Ms Deborah Shaw
Project Manager
St John of God Health Care
13 Grantham Street
Burwood NSW 2134

**St John of God Richmond Hospital Redevelopment (SSD-10394)
Response to Submissions**

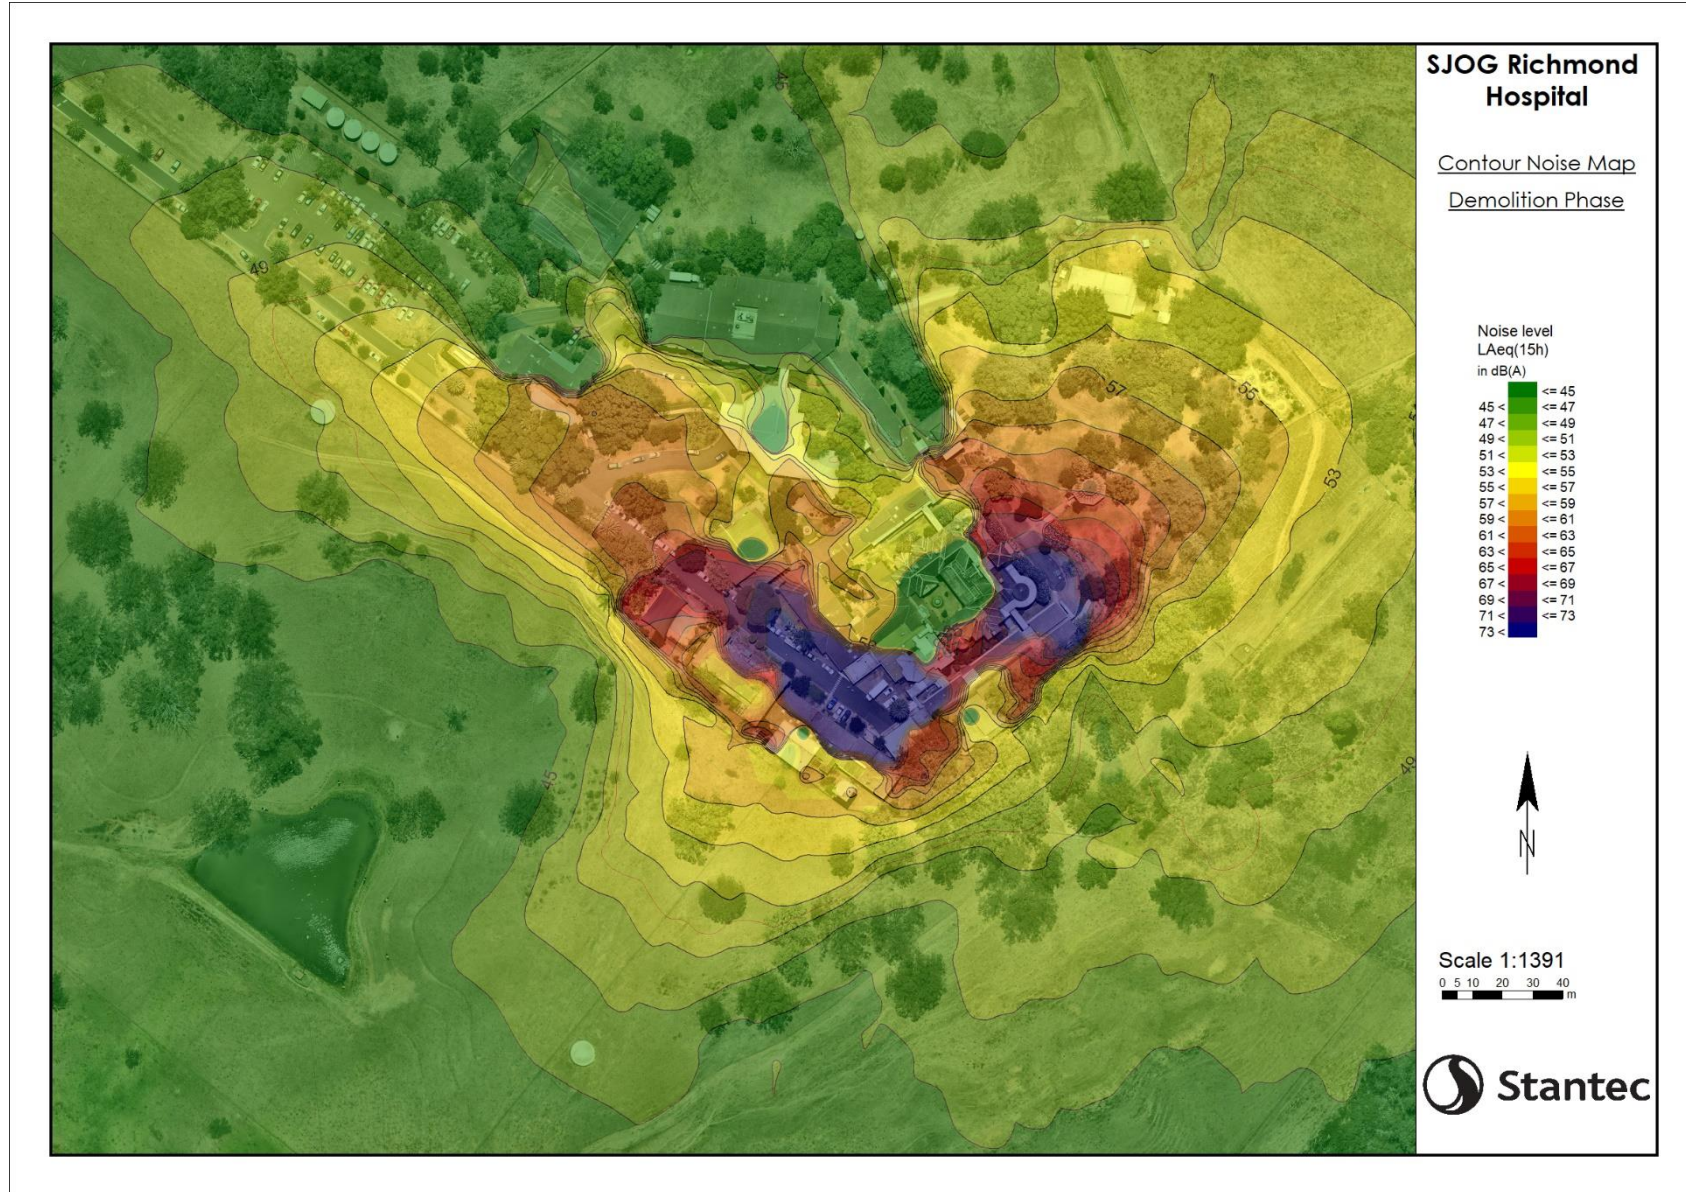
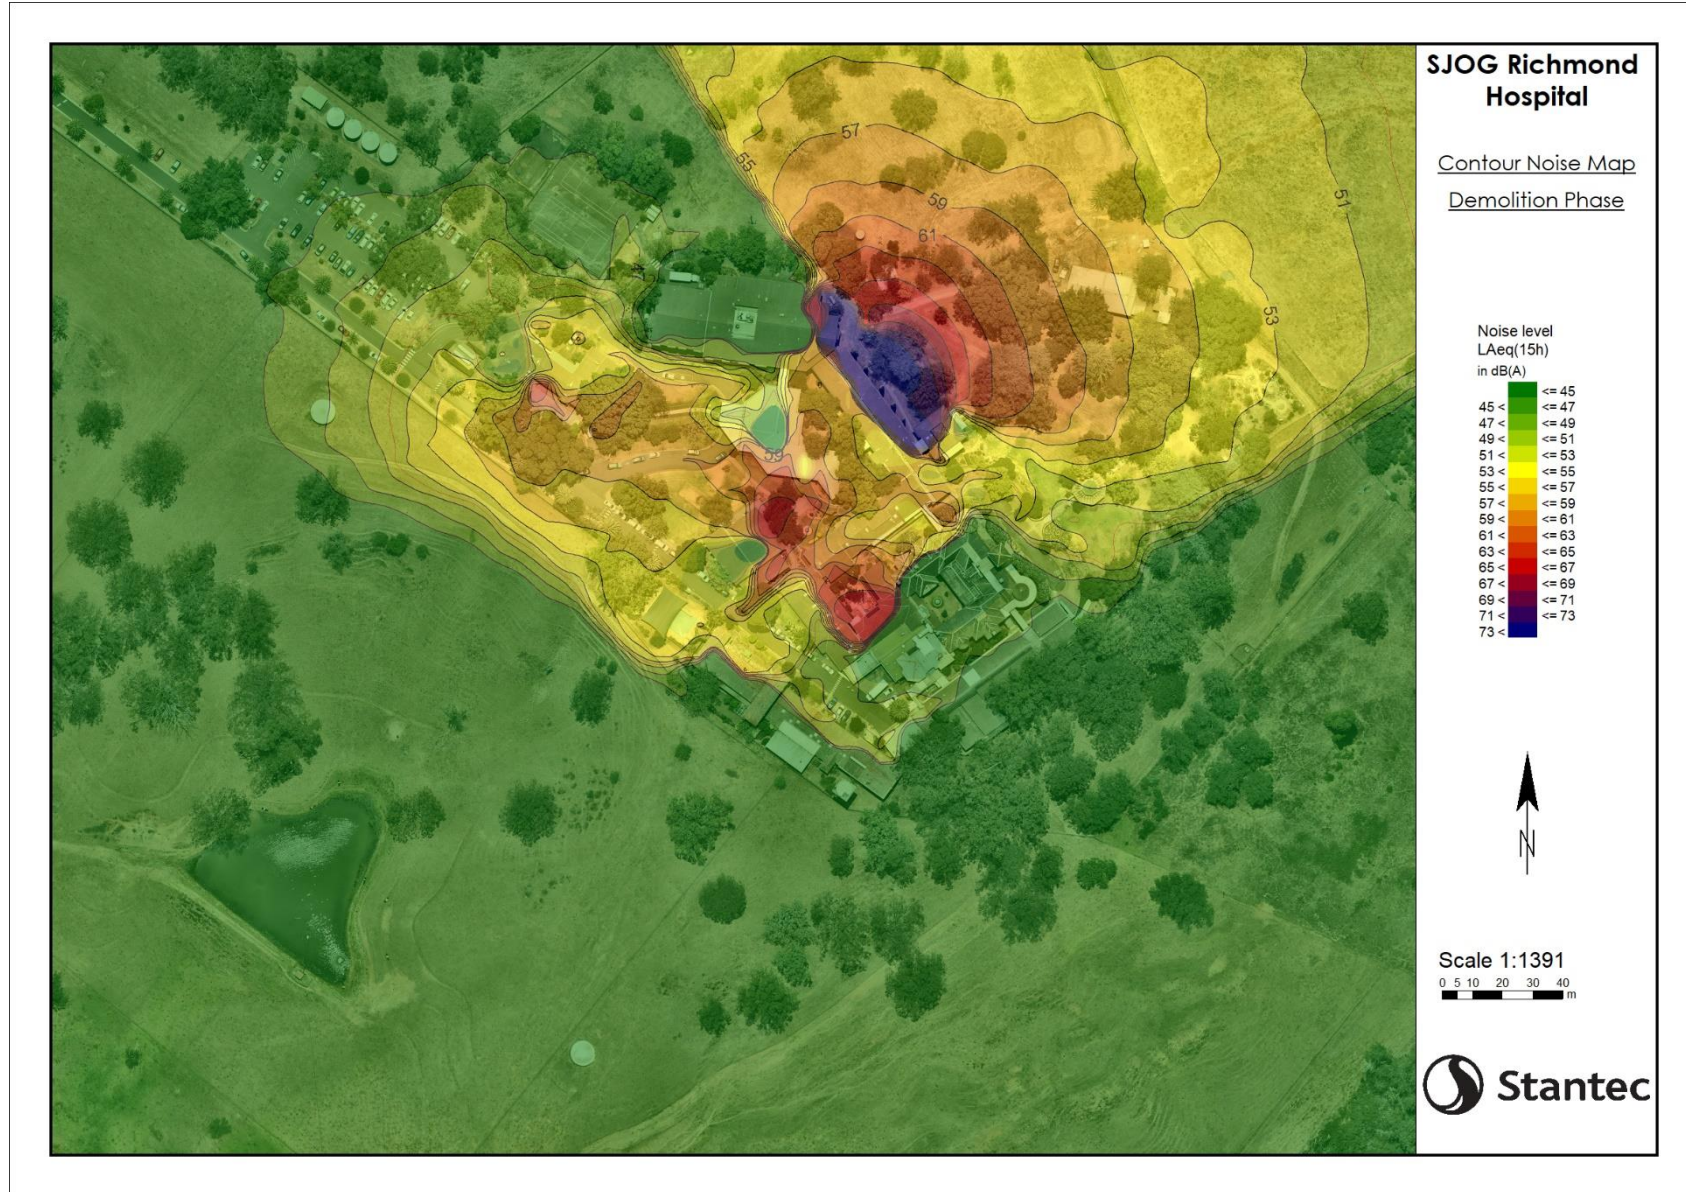
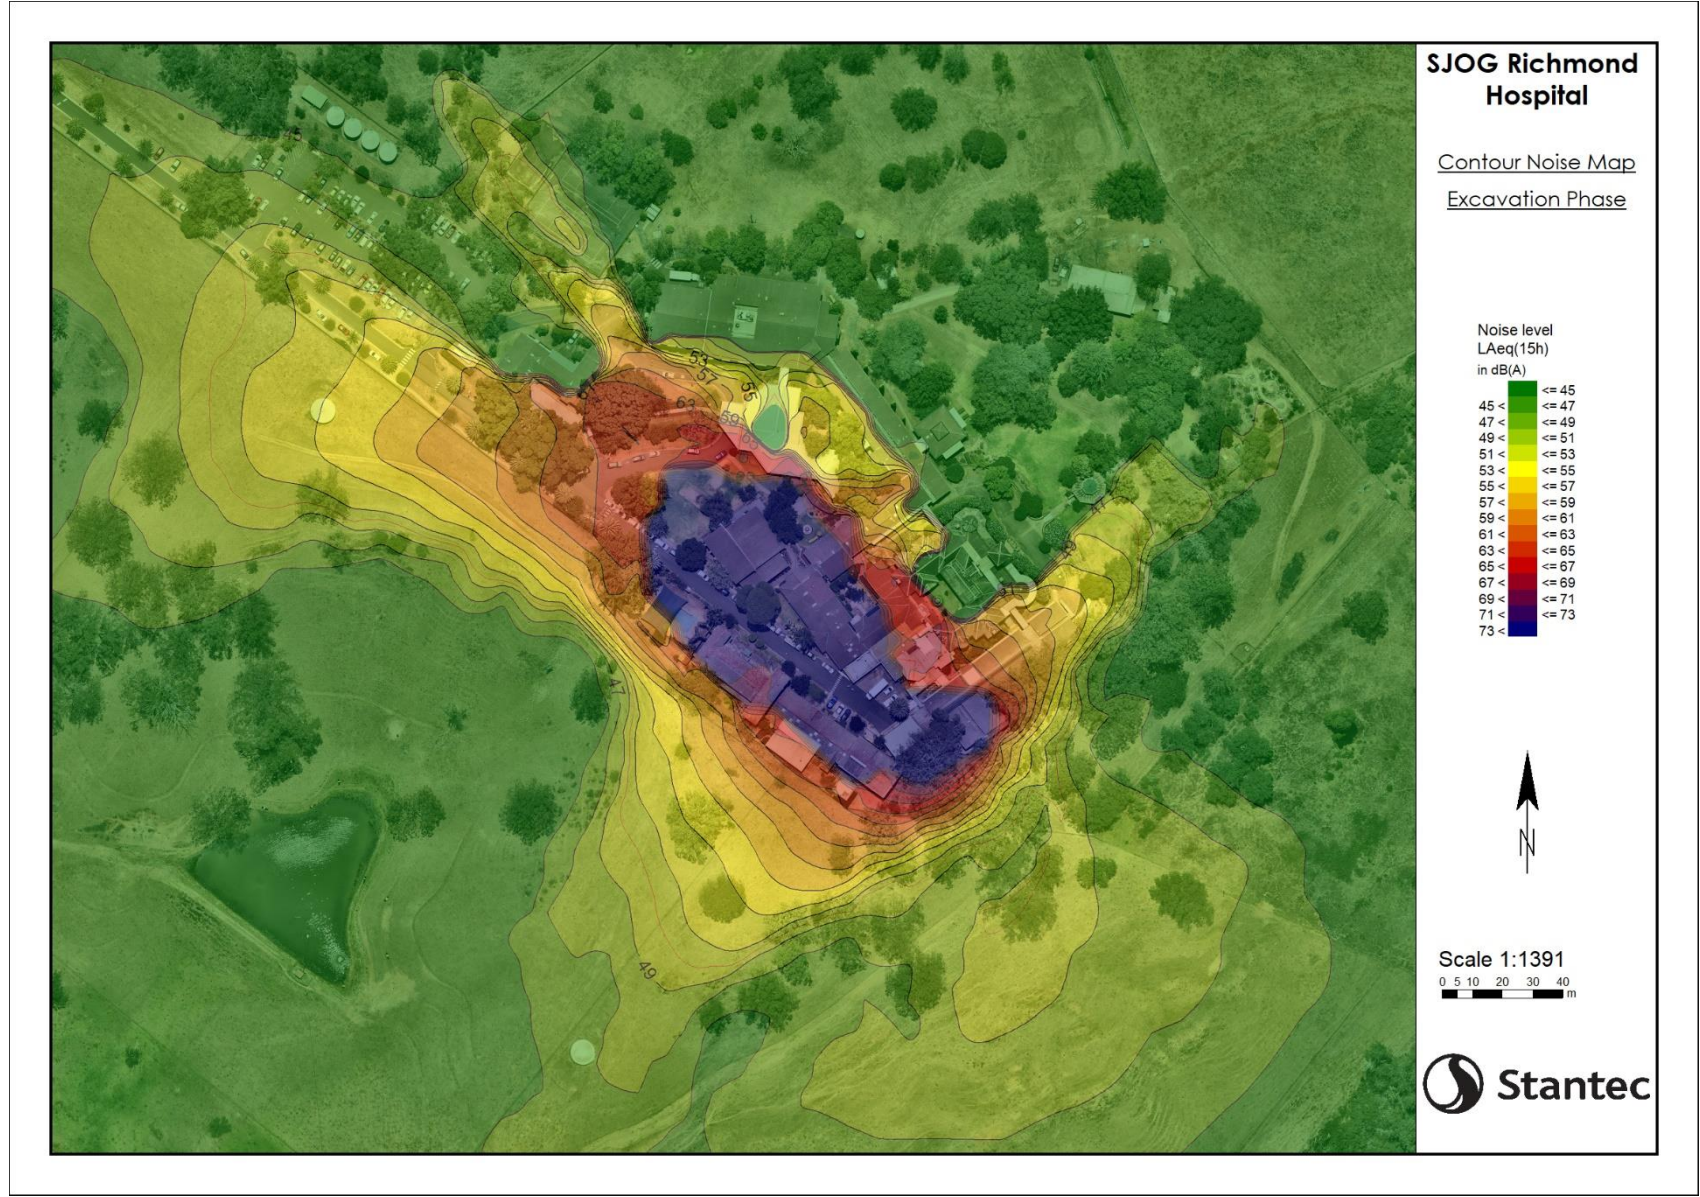
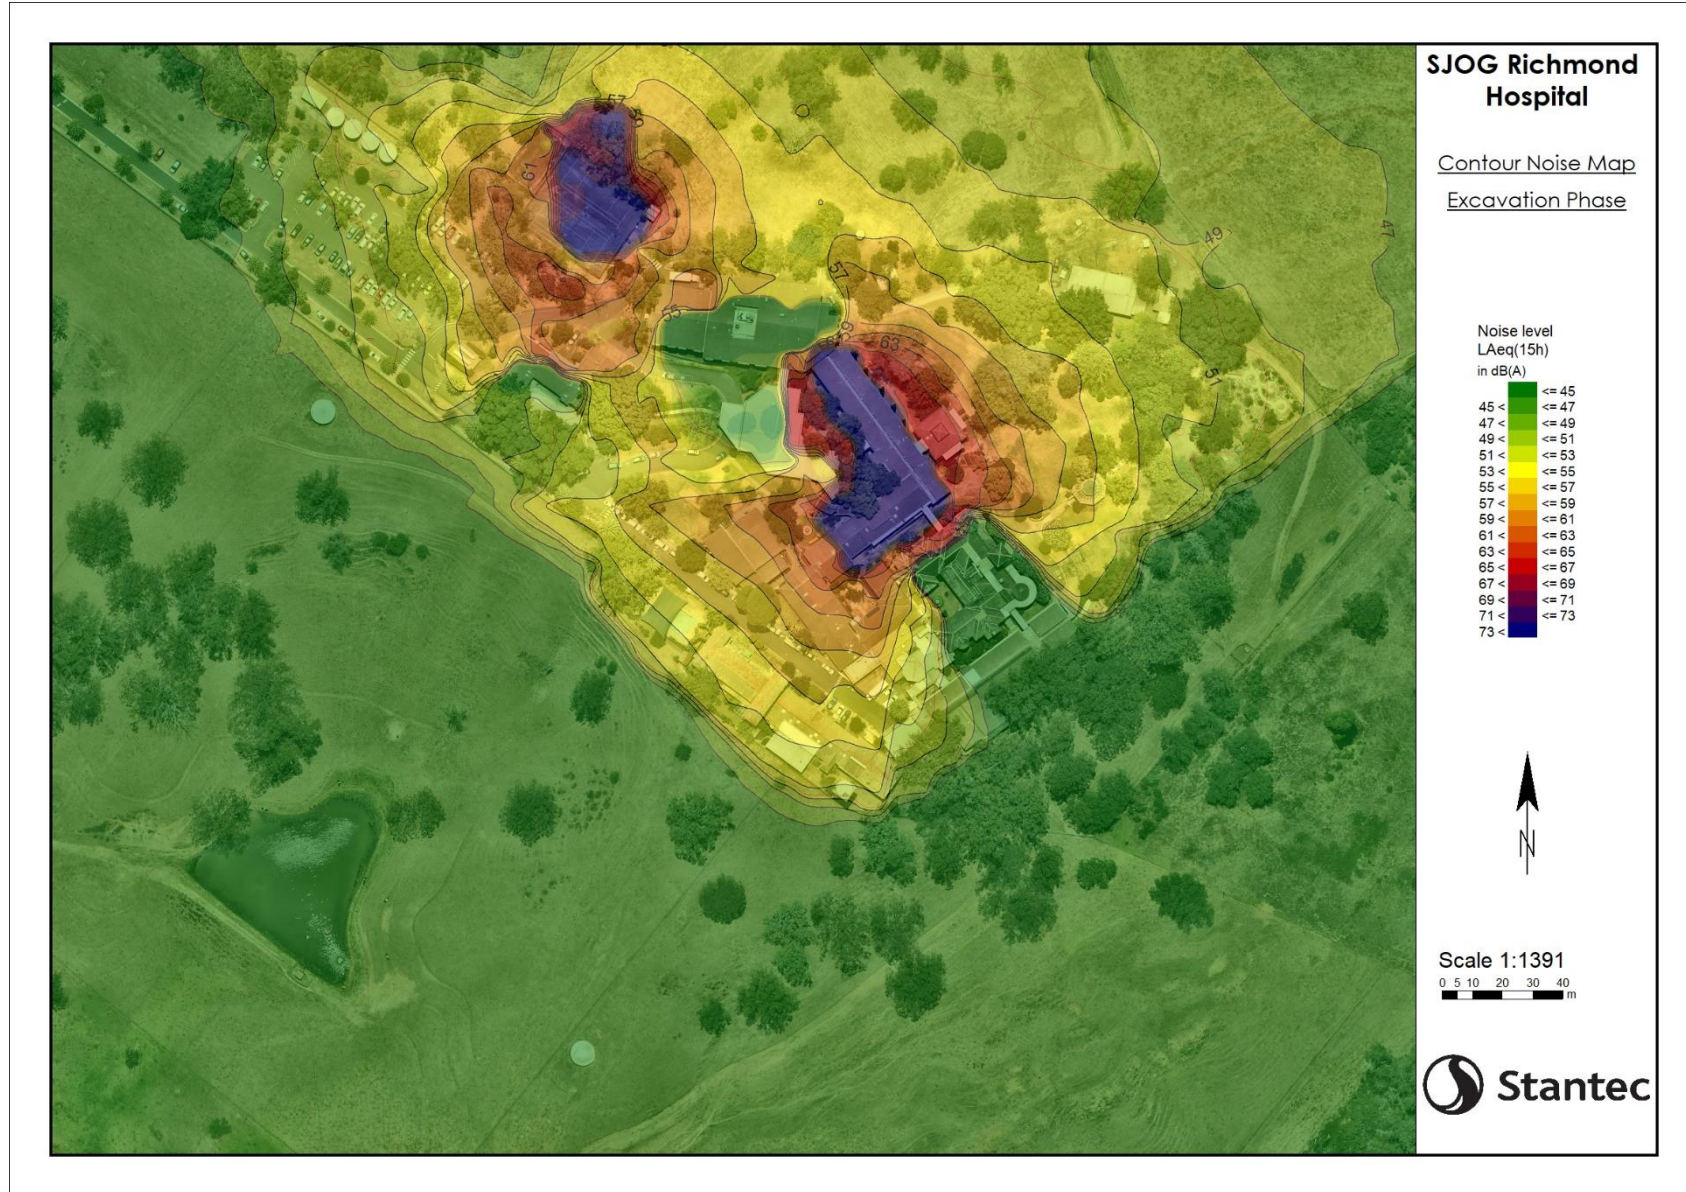
- Table 11, 12 and 13 of the construction noise report are to demonstrate the receiver locations as their positions on the subject site are unclear.
- consideration should be given to providing openable windows within communal areas to provide natural ventilation and cooling, rather than the use of mechanical air conditioning at all times.
- the clause 4.6 variation (Appendix 14) is to be amended to appropriately reference the height variation being sought (not FSR), and the height of existing structures is also to be provided for comparison purposes.
- consideration should be given to whether an updated Emergency Response Plan is required that accounts for the proposed increase in patient capacity at the facility, with particular attention given to flood evacuation procedures and practices.
